HAMMERS CONSTRUCTION, INC

REVISION RESPONSE LETTER

RE: Rocky Mountain Cycle Plaza

DATE: April 14, 2026

1 of 7
SITE PLAN

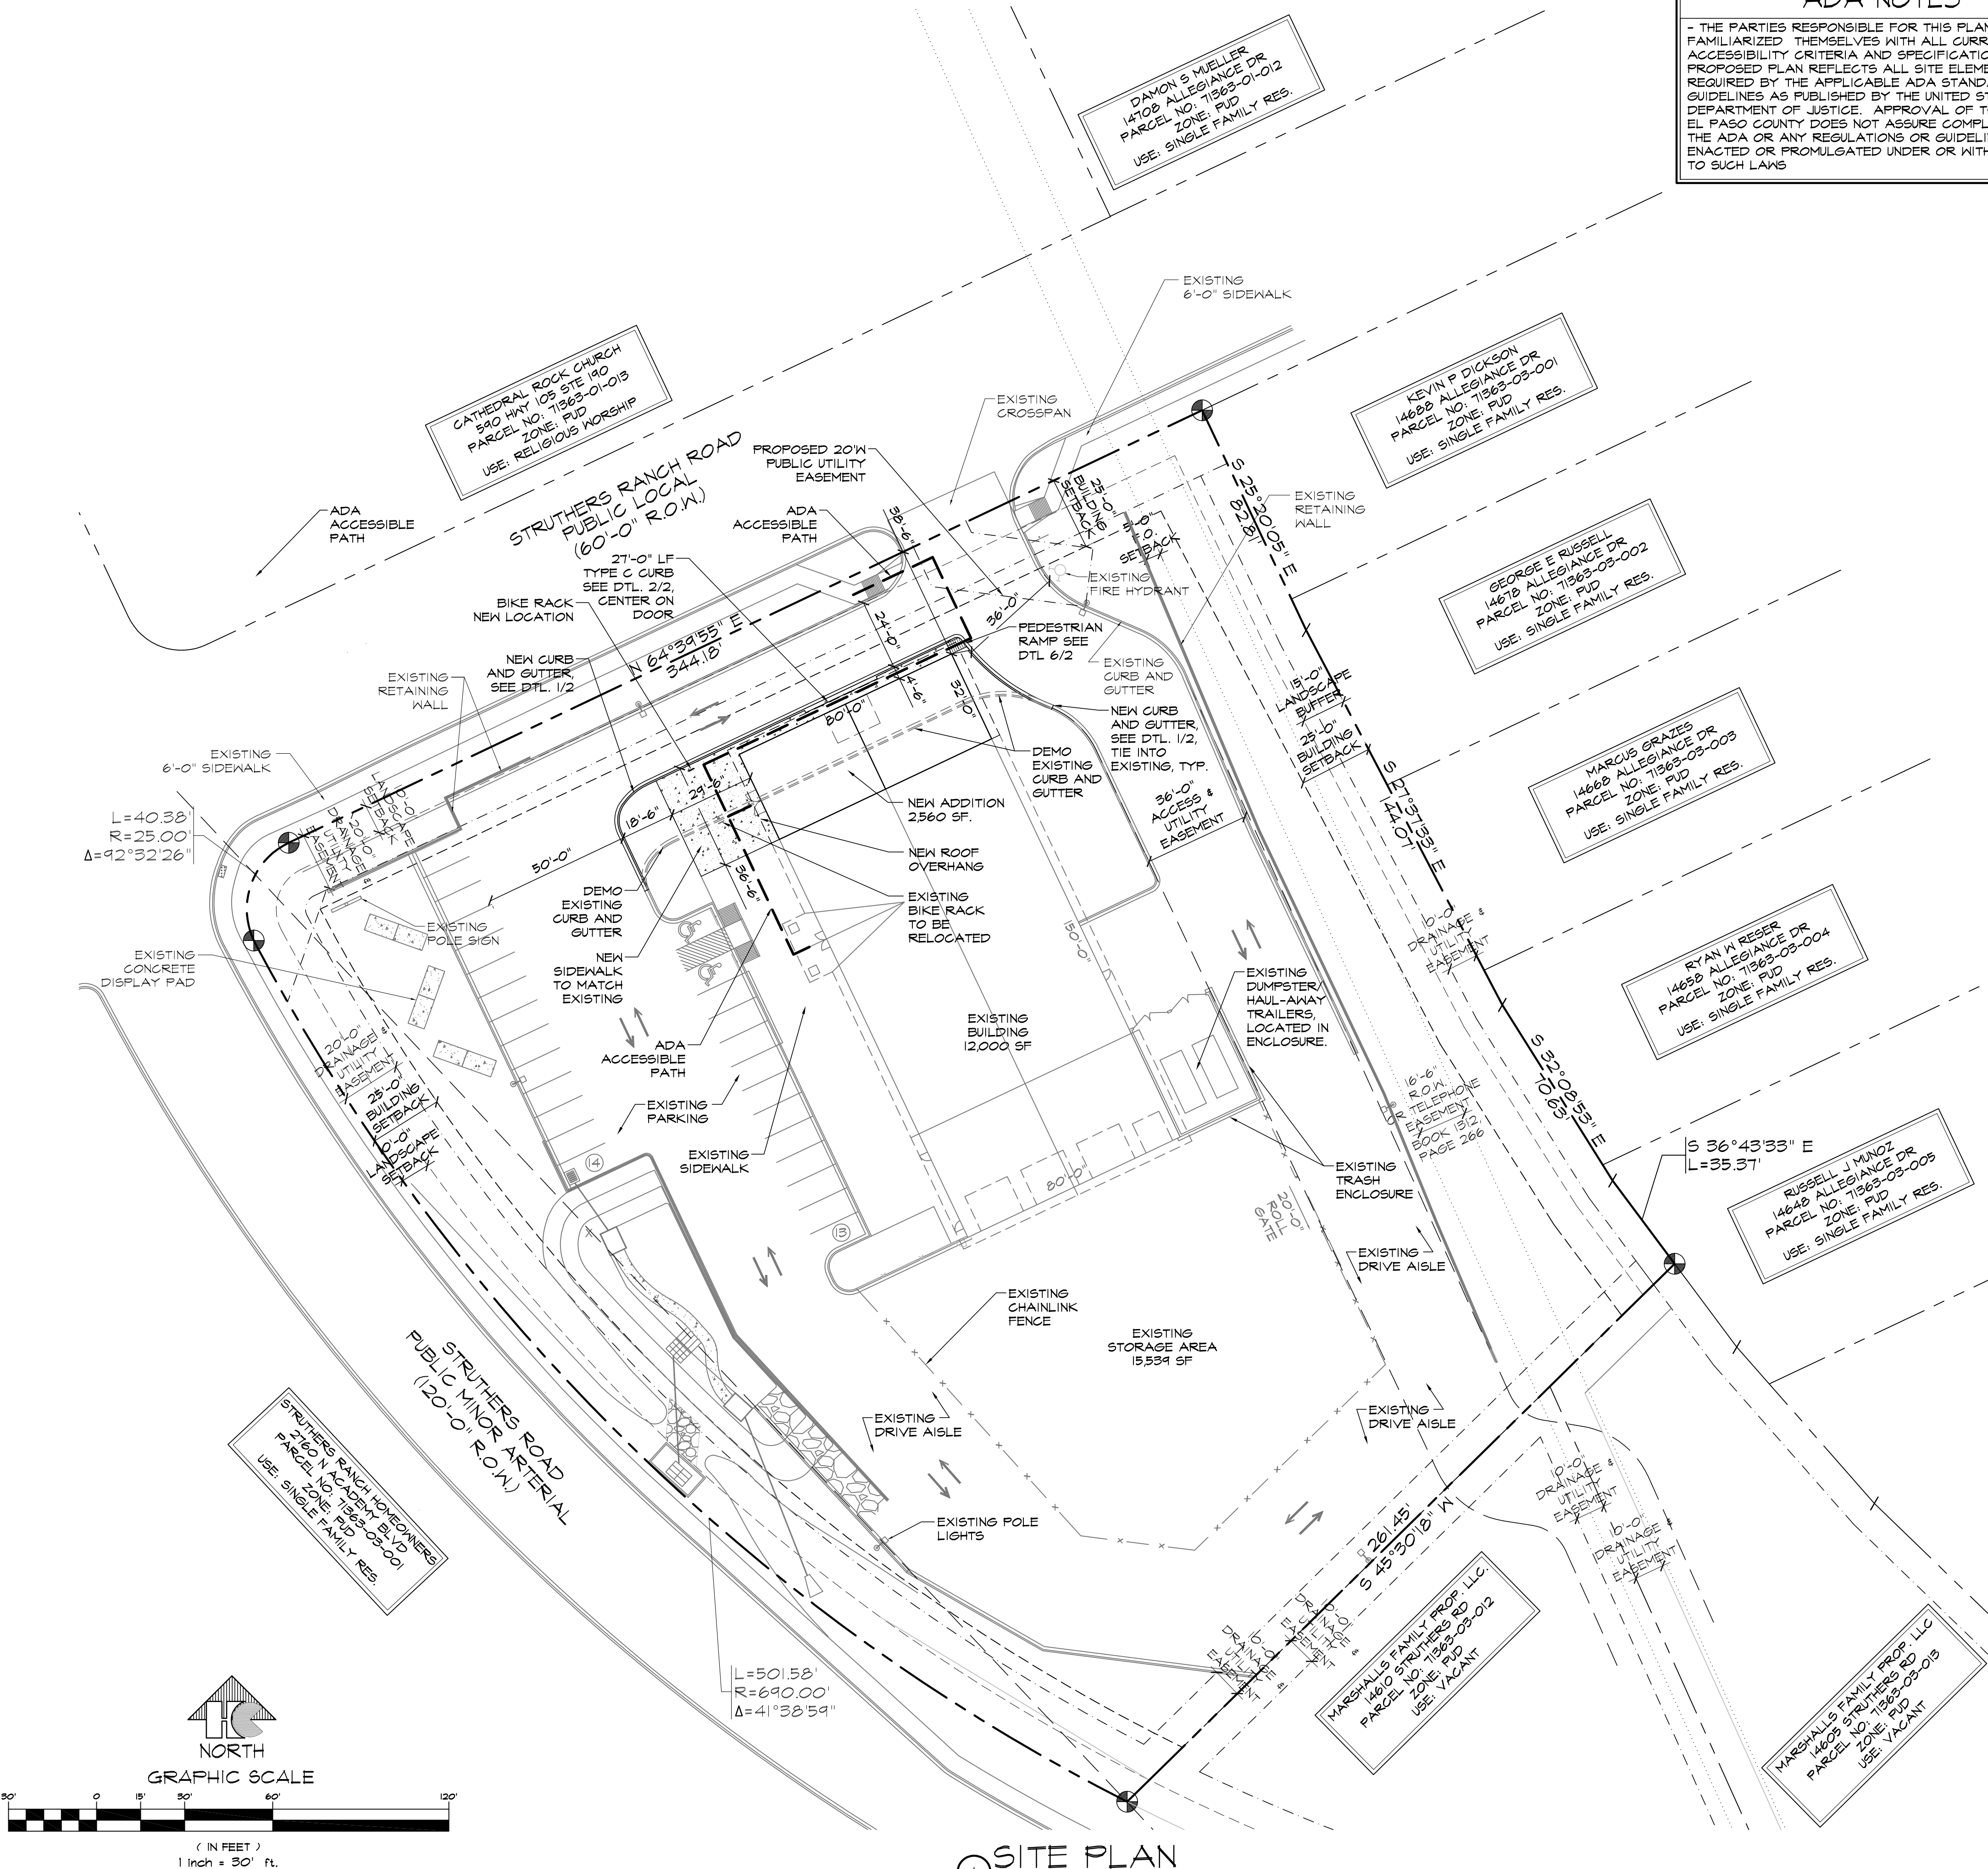
3. The Site Plan shall be updated to show the existing District fire hydrant, water distribution piping and existing District utility easement across the access drive from the northeasterly corner of the proposed building addition. **Site Plan has been updated.**

LANDSCAPE PLAN - AREA 'A'

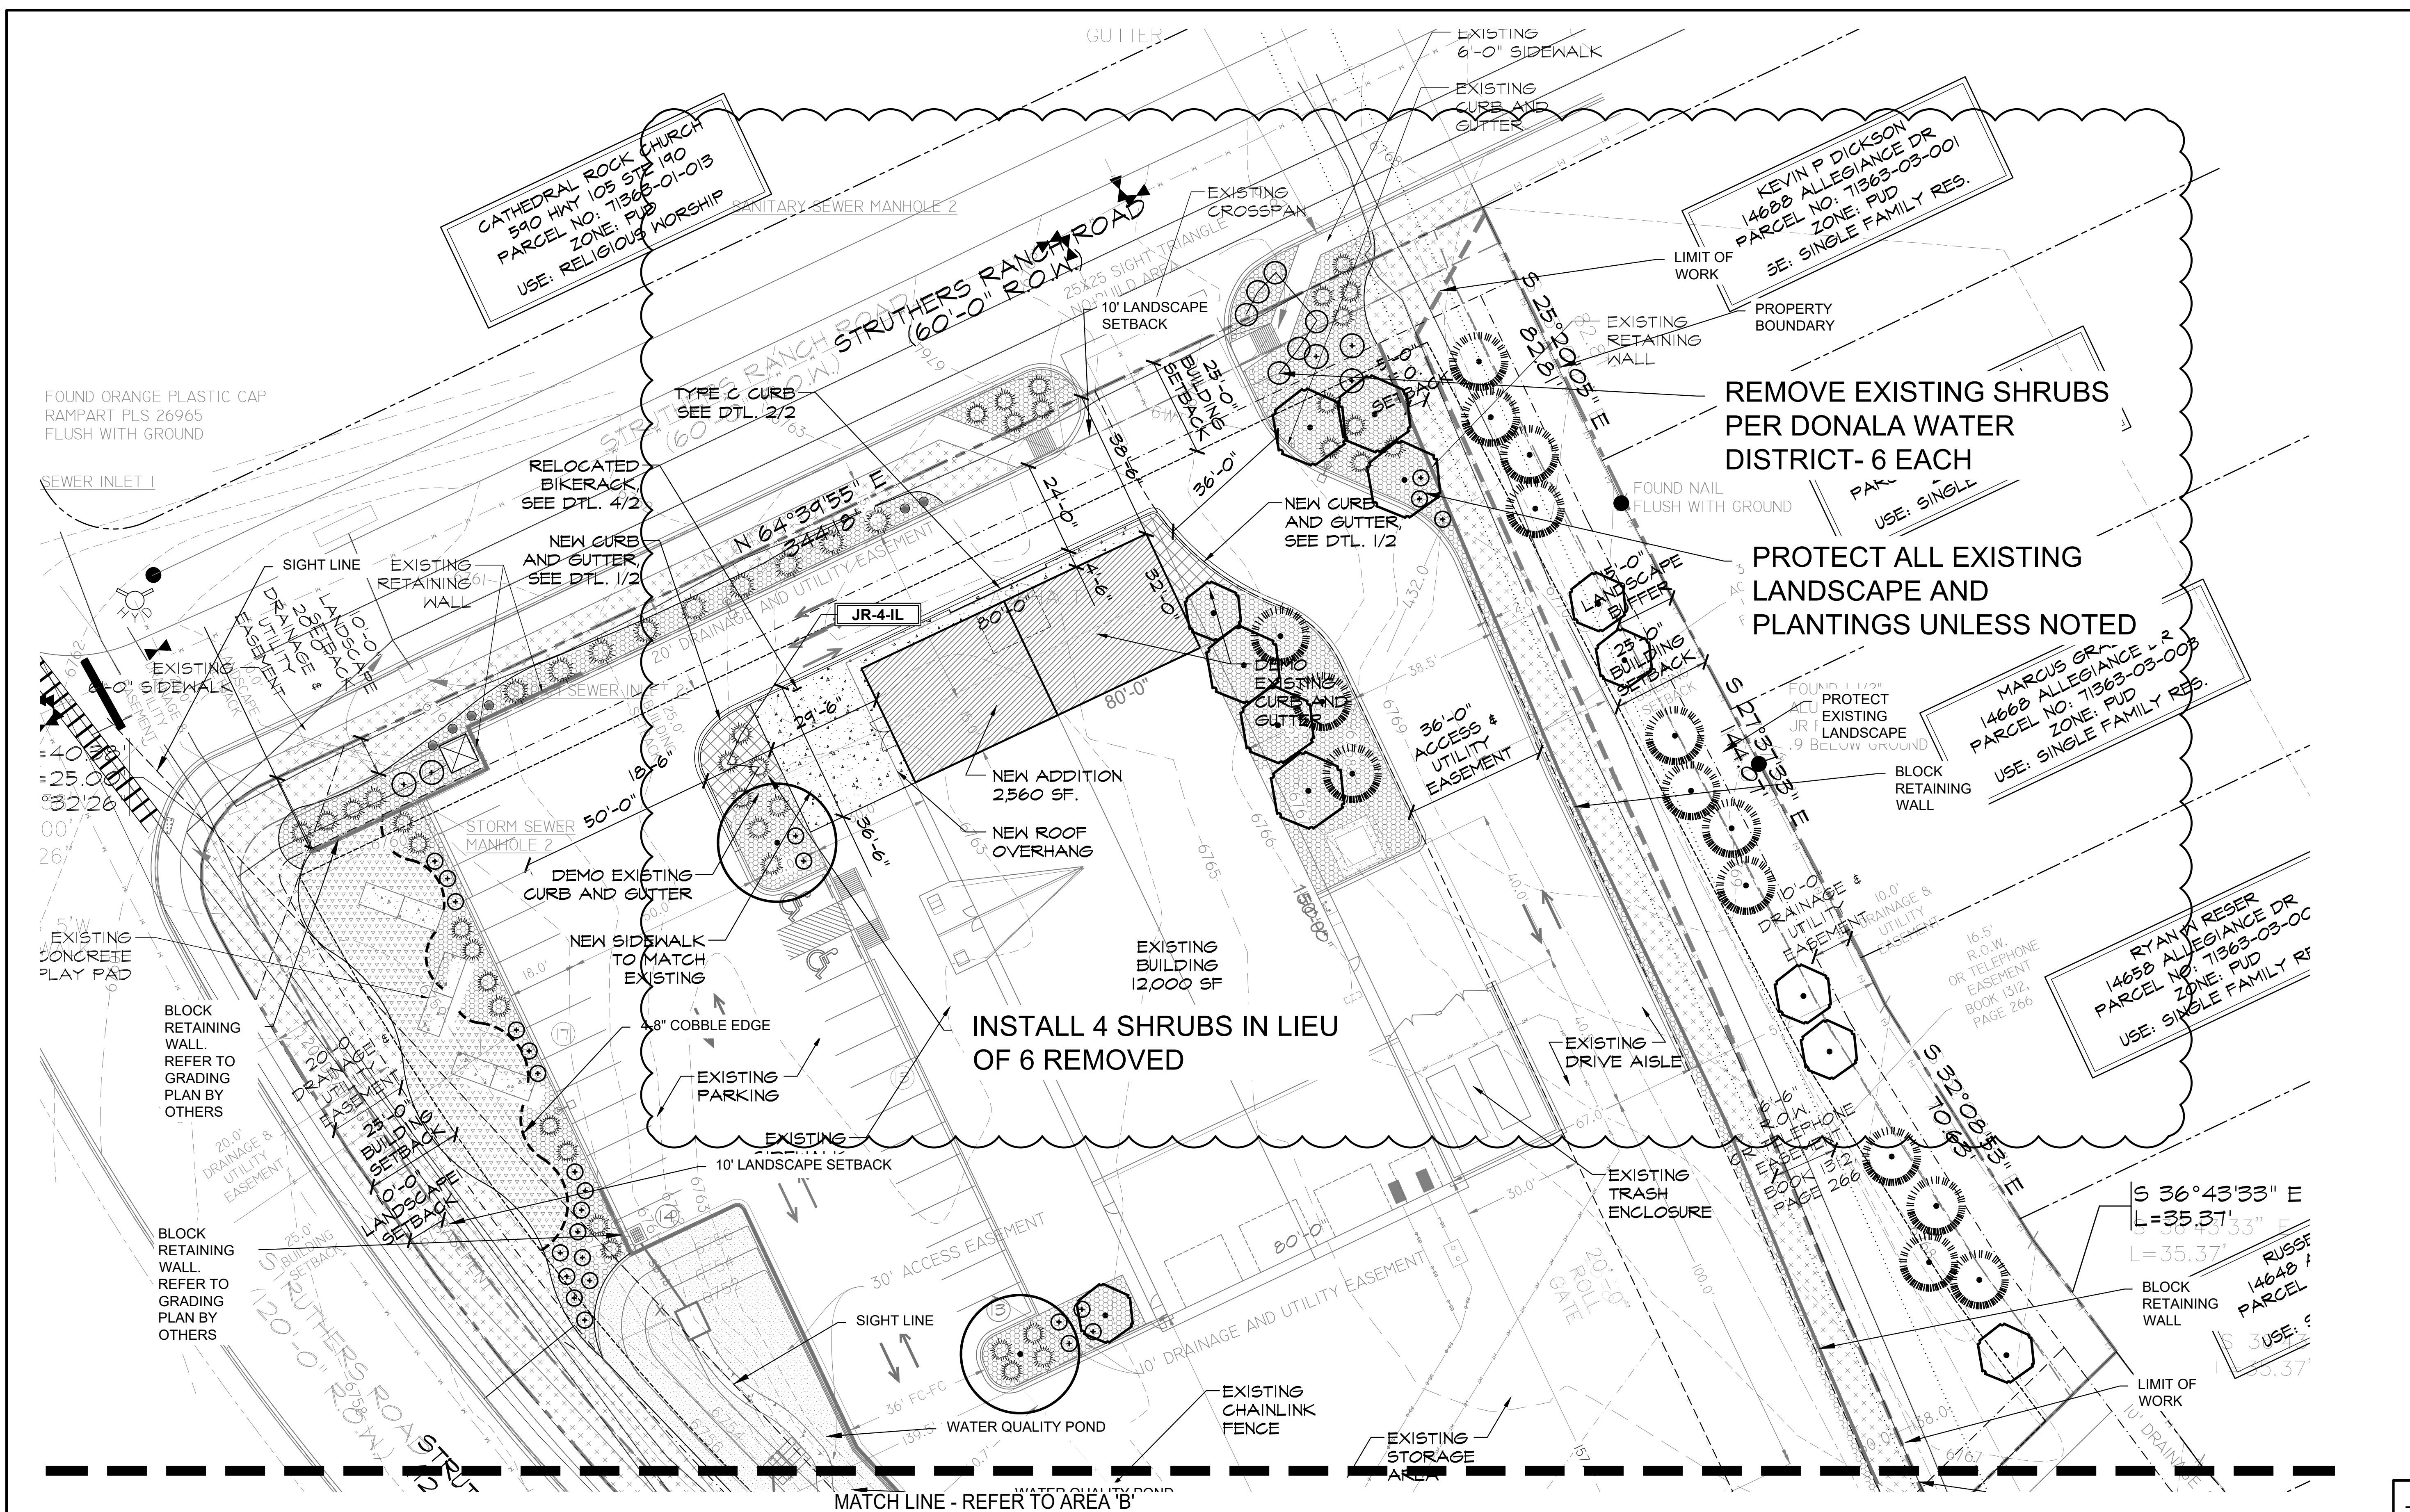
4. Revise the submitted landscape plan showing plantings at the east side of the access drive at the easterly side of the showroom addition. The plan as submitted does not reflect conformance with the District's request as expressed in the review comments of February 6, 2023. **This has been updated to depict existing conditions, as well as confirm no planting are within the easement as per District's request.**

The request was to revise the then existing landscape plan to maintain plantings no less than 10-feet away from the fire hydrant at the east side of the access drive. Based on cursory examination of the as-constructed plantings, it appears the request has been given attention but should be verified. There appears to be immature low grow shrubs within the 10-foot proximity although deciduous and coniferous tree plantings appear to be compliant with the District's request. Please revise the landscape plan submitted as part of the PPR263 application to reflect compliance with the District's requirement.
